From: [Planning](#)
To: [Dogger Bank South](#)
Cc: [Bill Symons](#)
Subject: EN010125 - Dogger Bank South
Date: 16 December 2024 10:37:39
Attachments: [REDACTED]

This development falls partly within the district for Beverley & North Holderness Internal Drainage Board.

The Board notes that there are compounds, haul roads and access crossings, as well as the “Onshore Cable Corridor” within the Board’s district.

Plate 4-18 Proposed access road with potential permeable passing areas

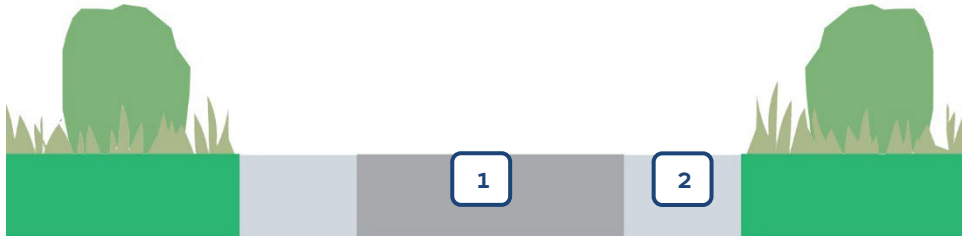
The Board would be wanting to understand the proposed drainage strategy for any haul road and compound areas. The Board's view is that Type 3 materials are "permeable" and Type 1 is "impermeable". Any impermeable areas (even if temporary) will generally require a formal drainage strategy.
